Demolish existing conservatory & erect 2 storey side & rear extension. New traditional front porch. Demolish existing garage & construct new carriage house & workshop to the front driveway

91 North Lane East Preston Littlehampton

Re: Planning Application No: EP/144/13

Block Plan
Garage Proposals
Planning Issue

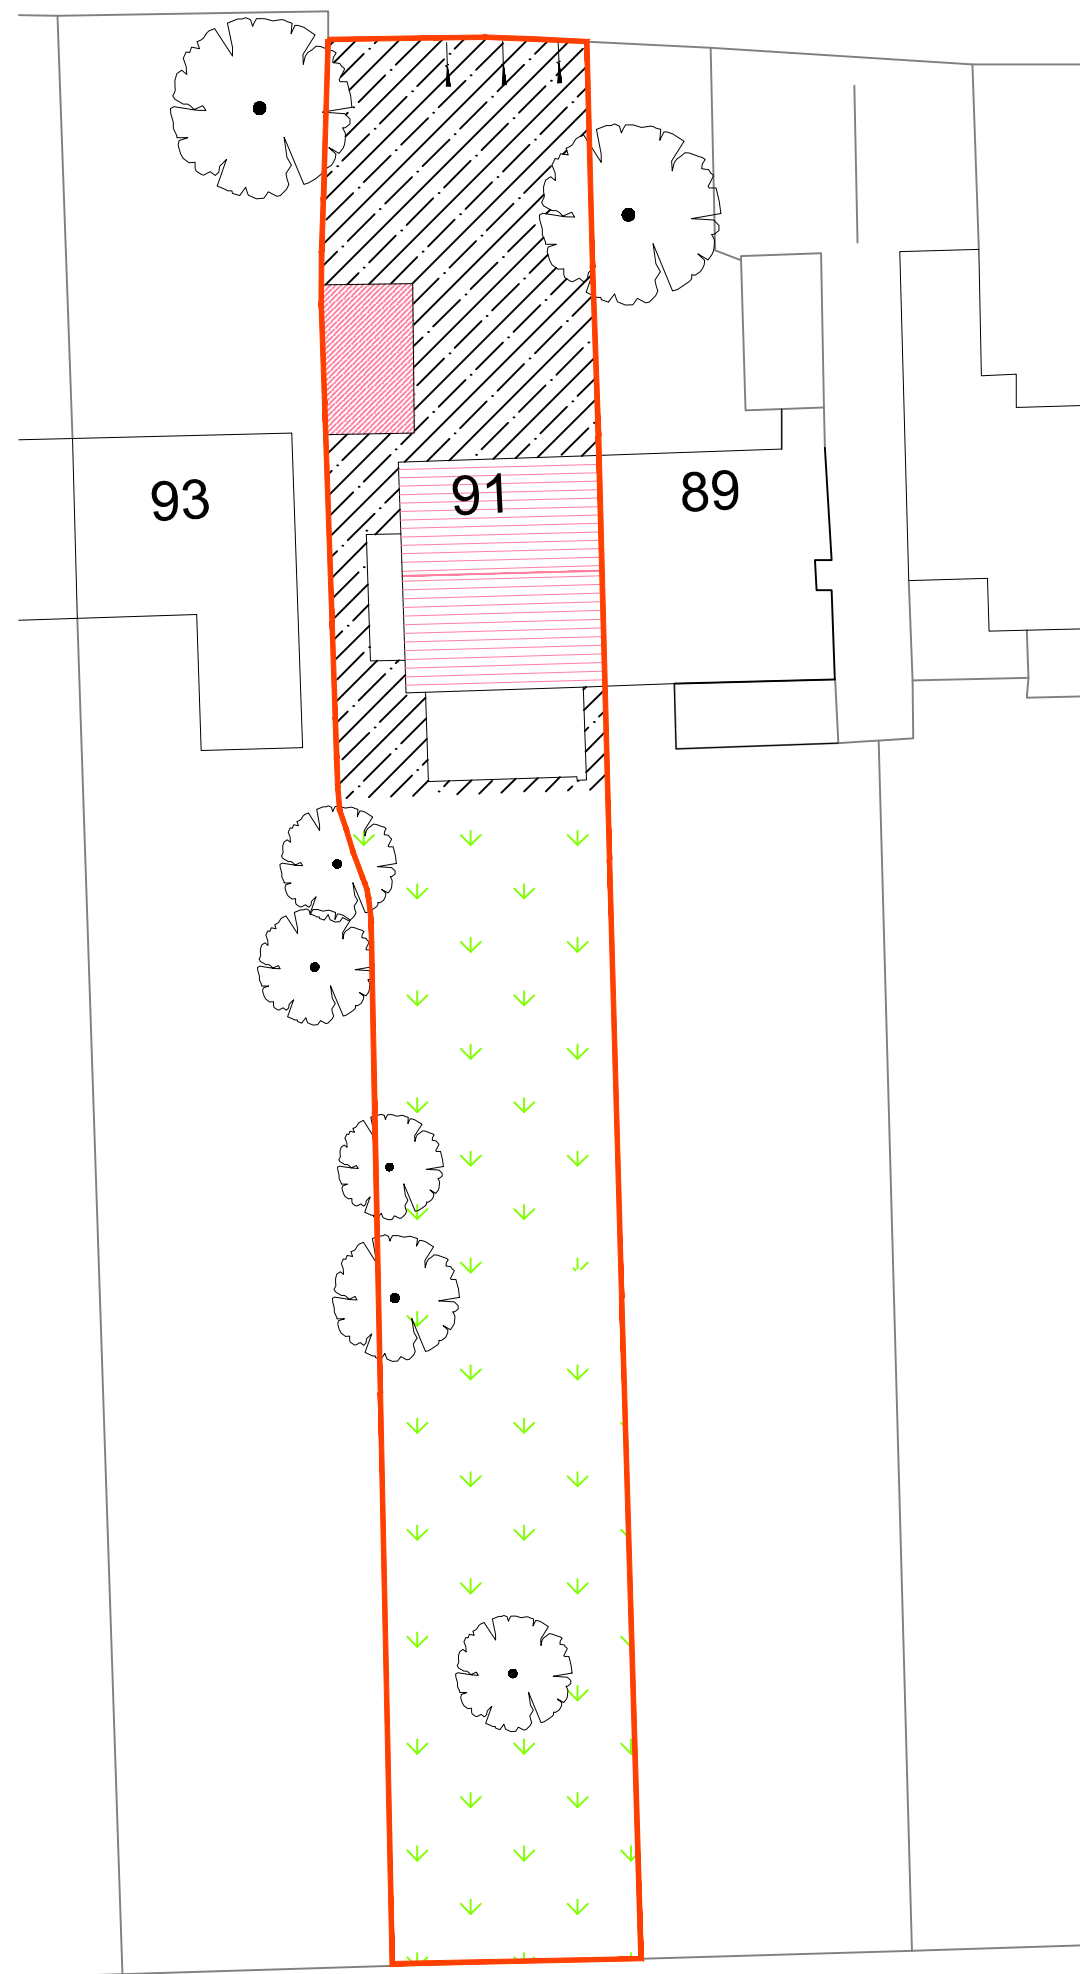
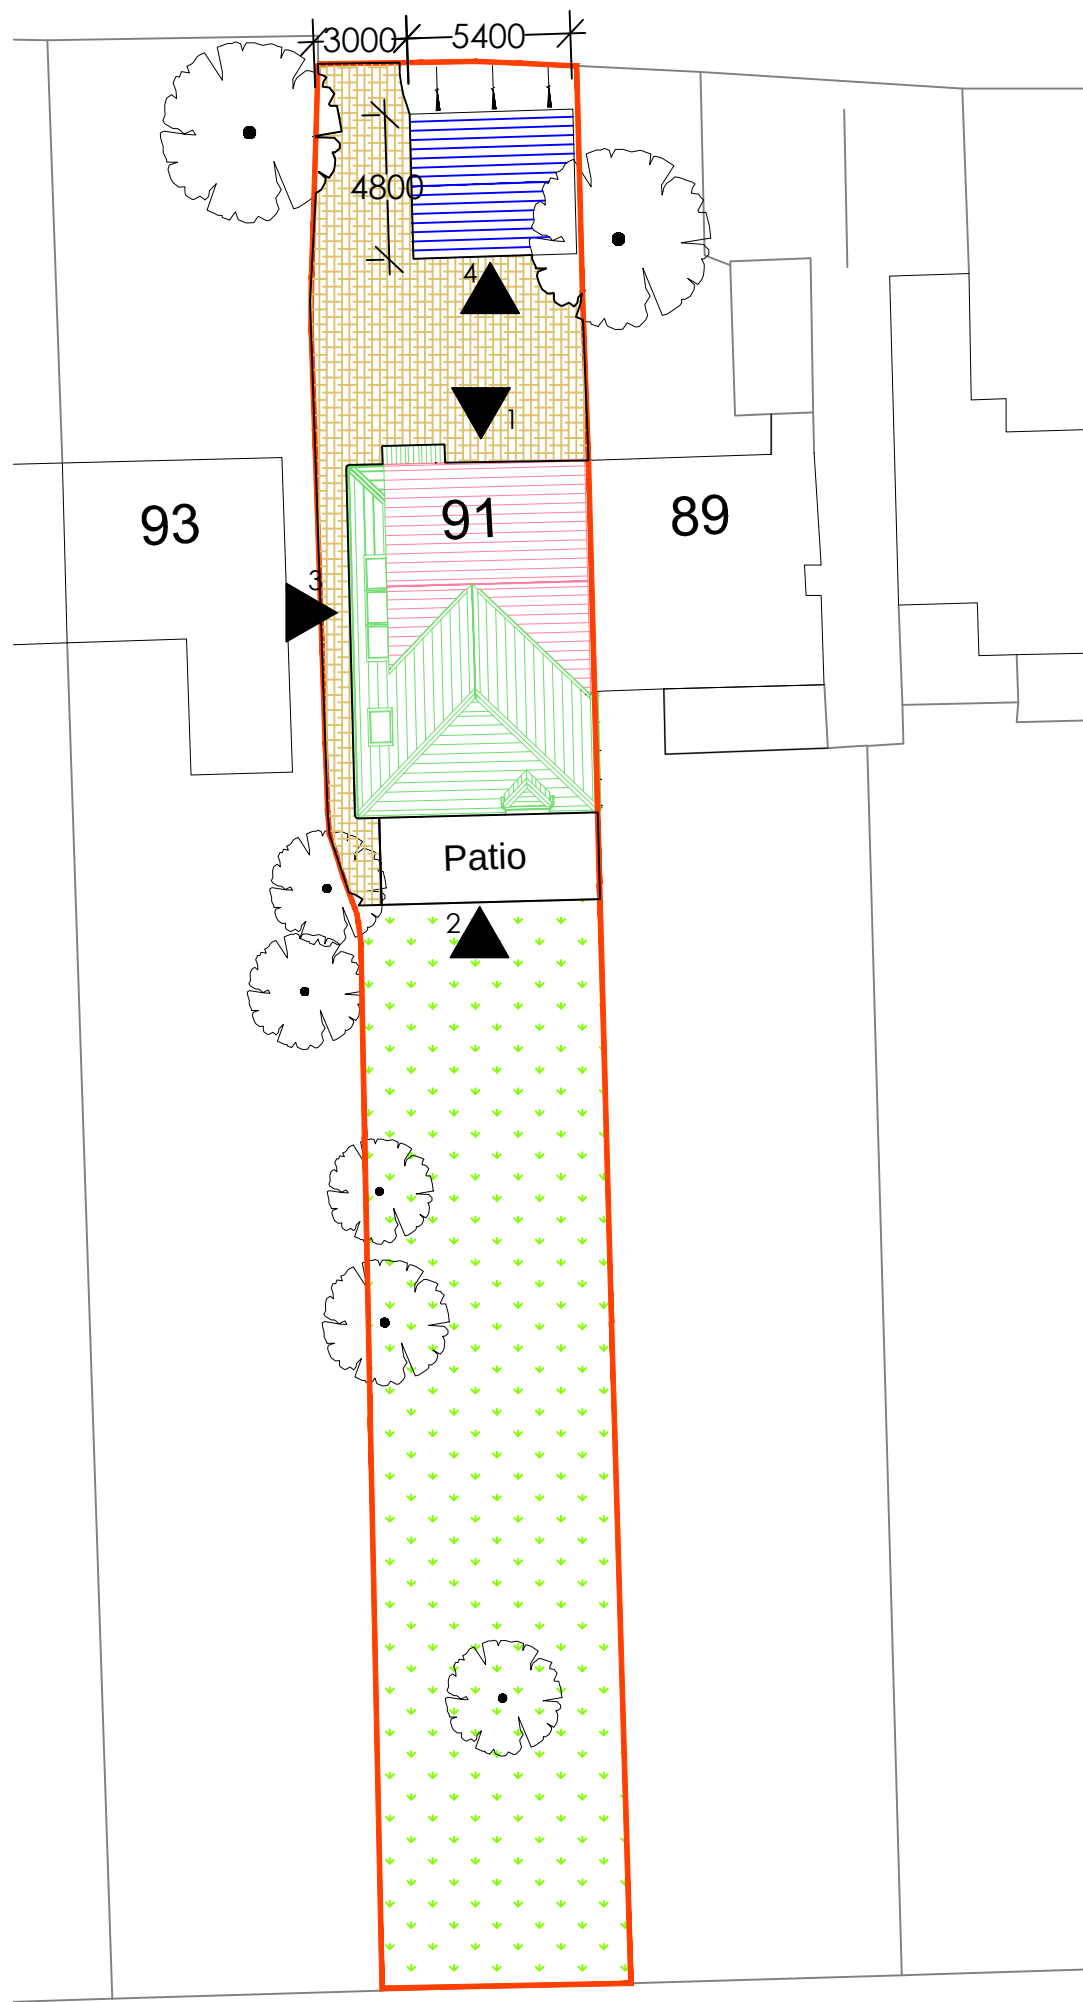
Upon looking at the OS maps and block plans it appears that our annexe is not shown to scale and therefore is misleading. The length of our annexe from our original building is 14 metres. This annexe although attached to our property is an independent dwelling and has its own address and has its own rateable value.

DRAWING
West Facing (Side Elevation)
Location Plan/ Block Ref
Planning Issue

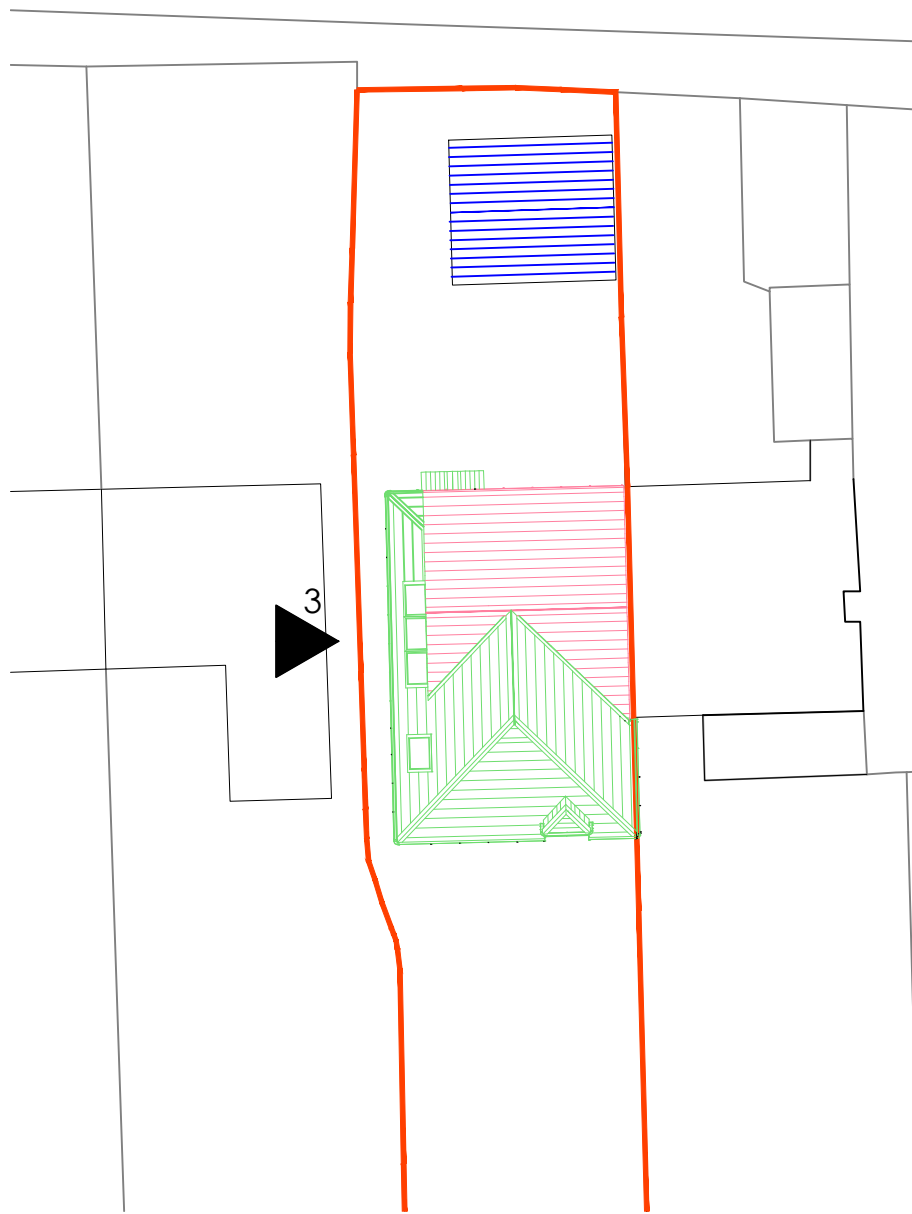
Overlooking & Light issues - We are owners of 89 North Lane and one half of the semi detached property adjoining 91 North Lane where the proposed two storey extension is to be built. These are Victorian semi detached cottages. We are very concerned that there will be overlooking and light issues as our bedroom and living room windows will look out onto the new building. There is an additional problem as we have a single storey annexe at the back of our property. My elderly father lives in this building. His bedroom, kitchen, bathroom and living room windows all face the side where the proposed extension is to be built. Not only will there be overlooking issues for both properties but we are also concerned that the size of the proposed building will block out any light into several rooms. The only windows in my father's annexe are on the side where the neighbours propose to extend.

We would not have any objections to a proposed extension that was a single storey development with a flat roof but the fact that they have proposed a building that is twice the height of our annexe with a sloping roof and will most definitely have an impact on our property, the light into our building and our privacy.
